## **Sibford Gower Parish Council**

**Planning Application No. 16/01834/Q56**  
**Parsons Barn Farm, Shutford Road, Sibford Ferris OX15 5AD**

**Sibford Gower Parish Council therefore wishes to oppose the application.**

Existing Plan Layout
Scale 1:100

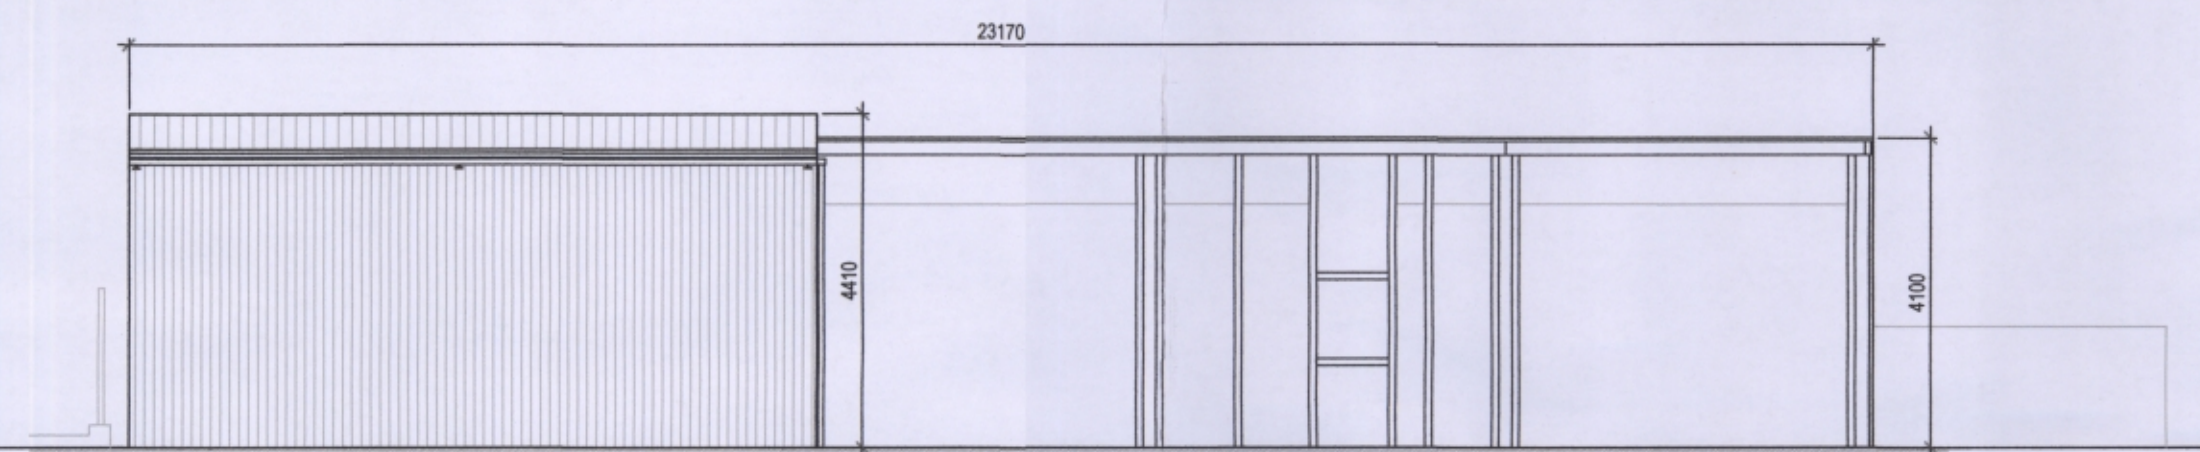
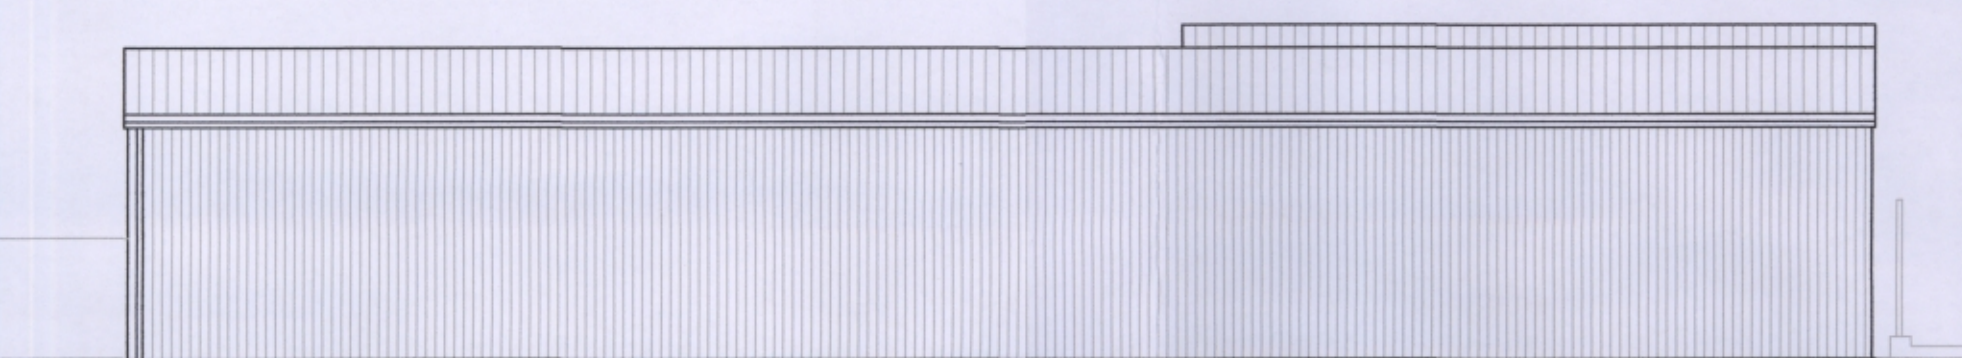
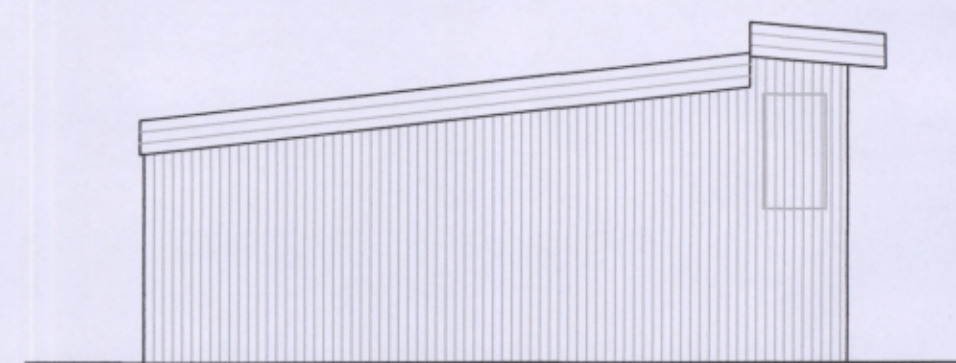
**Conclusion:** The application is not for conversion of a barn, but of an open shed partly earth floored and constructed from earth-sunk old telegraph poles and tin walls under an asbestos roof. There are no foundations. Under the regulations it has to be capable of functioning as a dwelling to start with and structurally sound. It does not therefore qualify for conversion under the Redundant Agricultural Buildings regulations.

Proposed Plan Layout
Scale 1:100

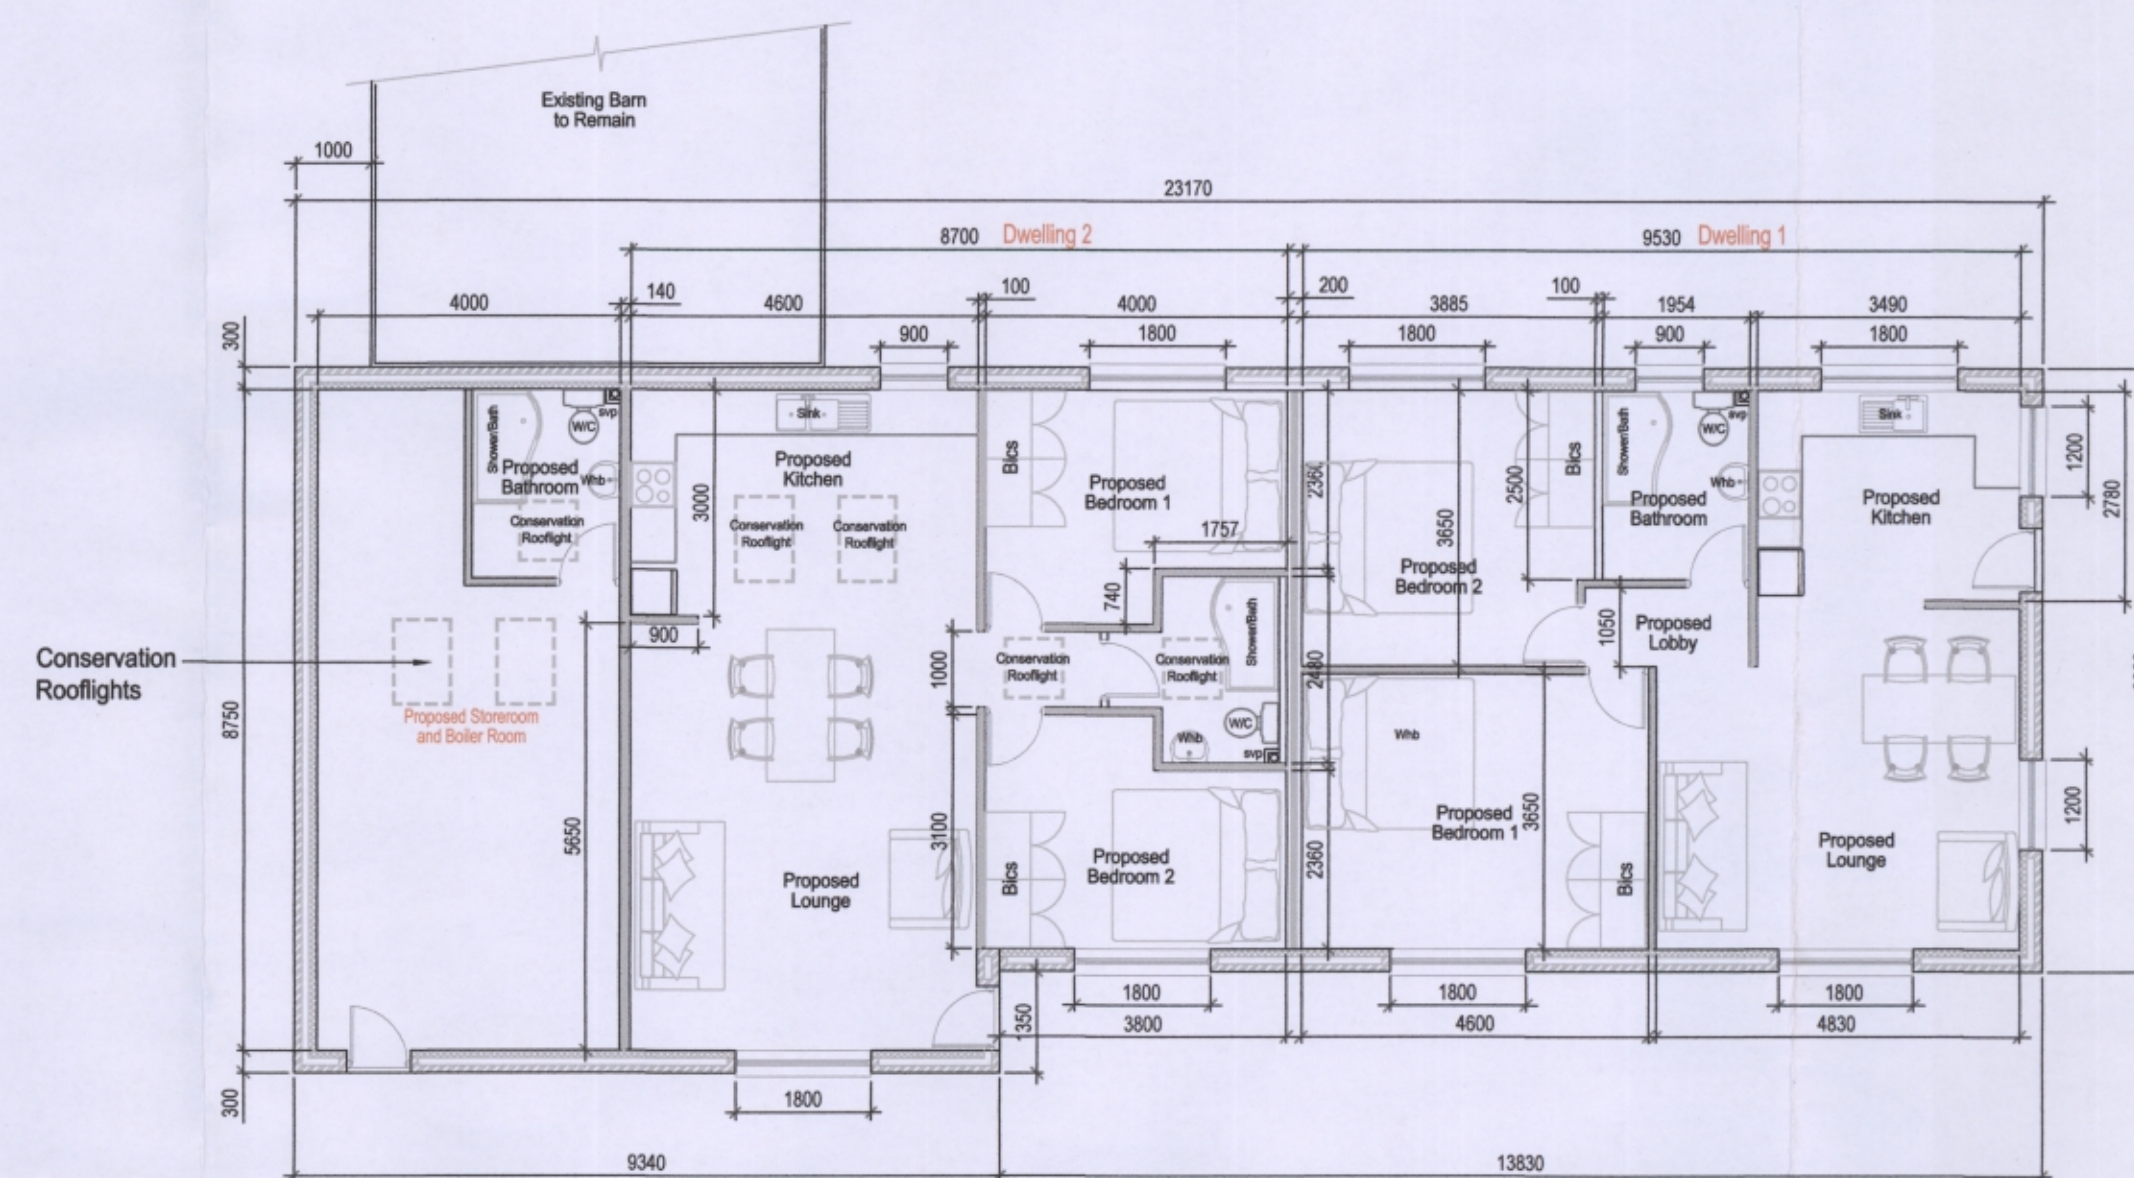
The plans proposed do not seem to add up to dwellings suitable for human habitation, being largely lit by skylights.
